Our Ref: SYD13/01444/02  
Your Ref: SSD 6324

**PROPOSED SUBDIVISION OF BRINGELLY ROAD BUSINESS HUB  
BRINGELLY ROAD, LEPPINGTON**

Roads and Maritime has reviewed the submitted information and provides the following comments to the Department for its consideration in the determination of the subdivision application:

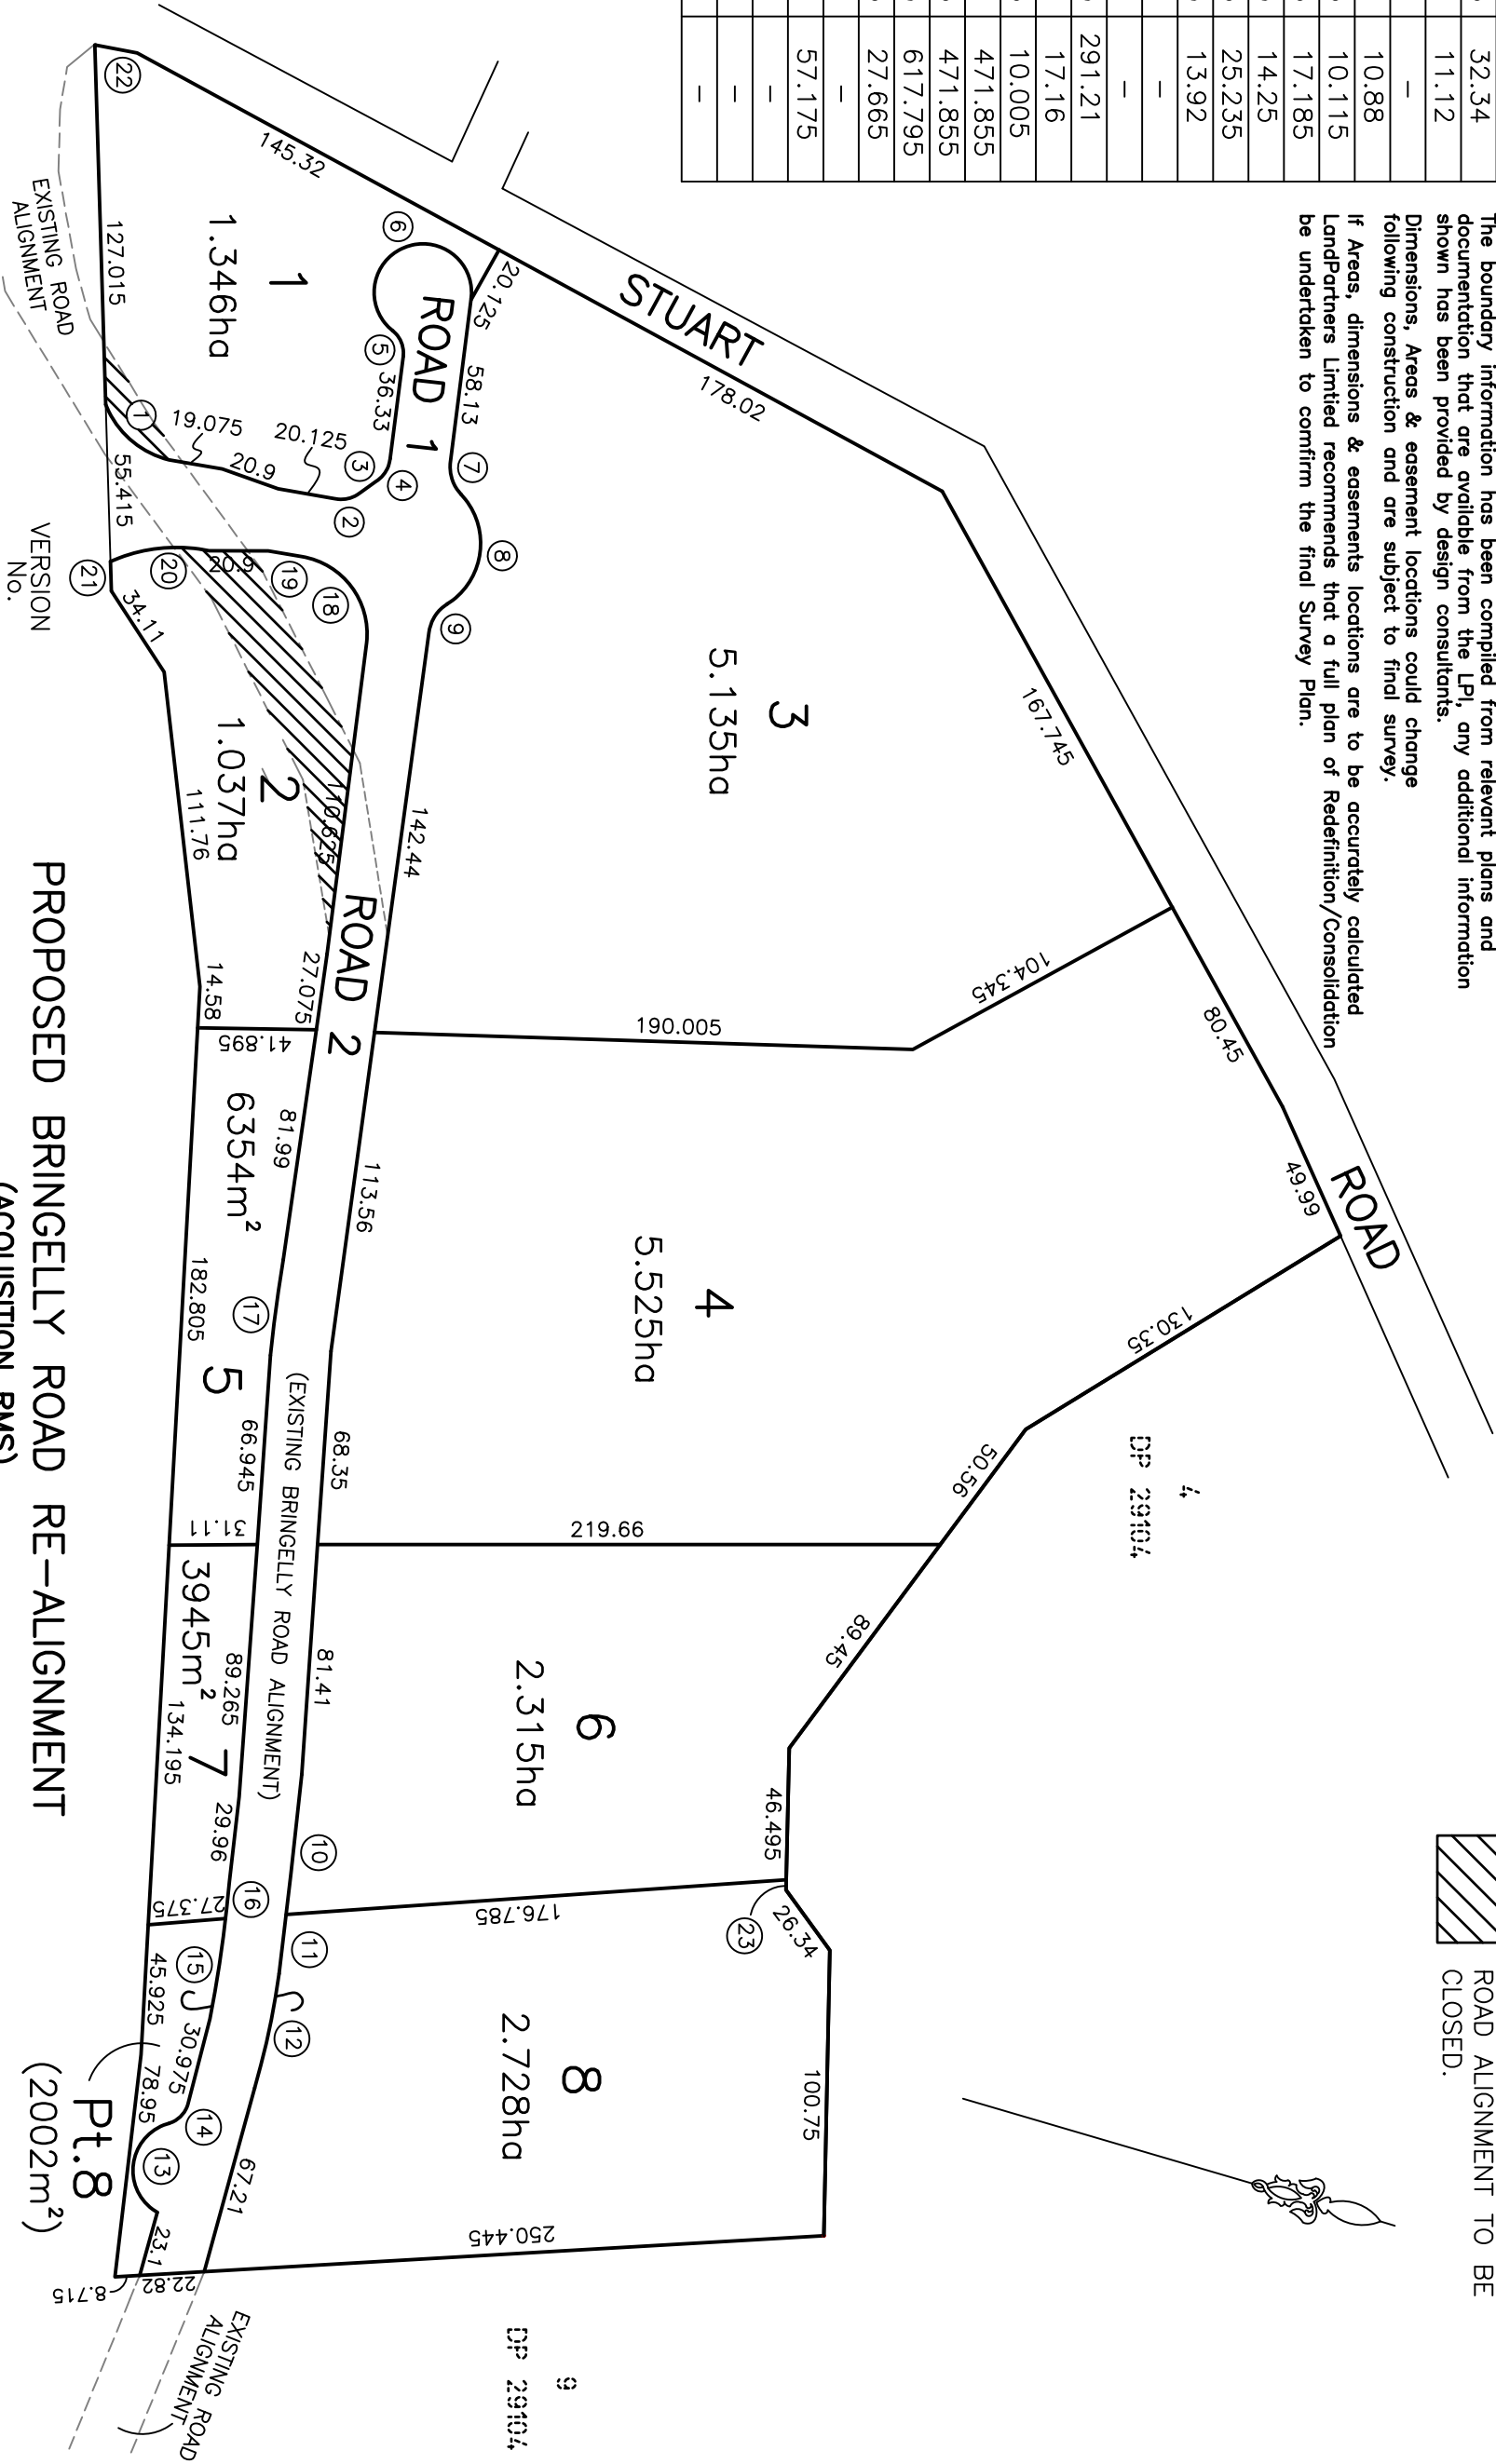
2. The subdivision should allow for future access from internal Road 1 to Lot 9 DP 29104, which is not part of this subdivision application. Roads and Maritime will not support any future customer access from Cowpasture Road to this lot.
3. In order to separate delivery vehicles from customer vehicles, the proposed 'truck lane' should be extended along the back of Lots 6 and 8 and should be connected to Cowpasture Road. The Cowpasture Road connection shall be restricted to left-in and left-out movements only. A deceleration lane shall be constructed at this location to maintain road safety and traffic efficiency along Cowpasture Road.

4. It is noted that only one access is proposed for the whole subdivision. It is recommended that a separate access from Stuart Road for emergency vehicles is provided.
